20 June 2018

Proposal: SSD6334 State Significant Development – Sutton Forest Sand Quarry

Jillian Reynolds
Fisheries Manager
Aquatic Ecosystems – South Coast

Figure 4 – Water Quality Sampling Locations

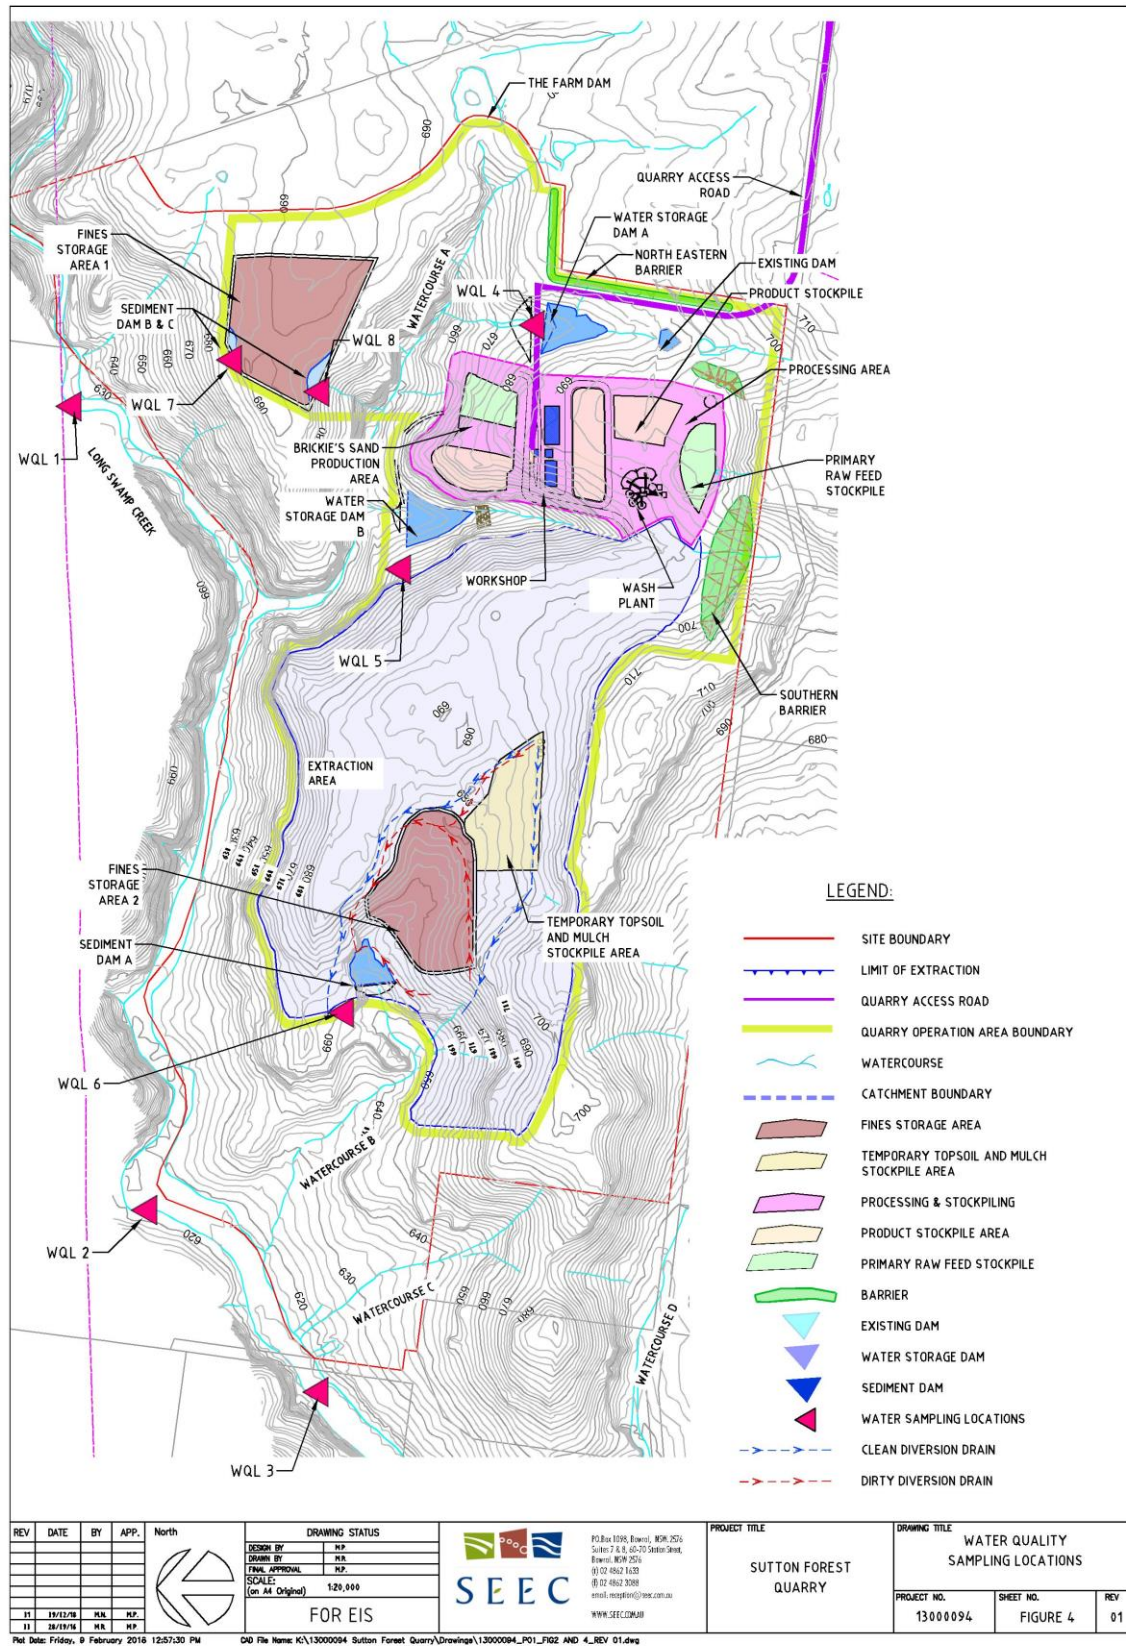
Planned water quality monitoring proposes the collection of baseline water quality data **following** the commencement of onsite activities. In order to obtain accurate data from the current or pre-developed situation, baseline data must be collected **prior** to commencement of any works within the footprint. As was identified in the Surface Water Assessment, at least 18 samples collected over a 2 year period is required to obtain appropriate baseline data. Baseline data collection should be periodically (at least monthly), and event based (rainfall exceeding 25mm in a 24 hour period).
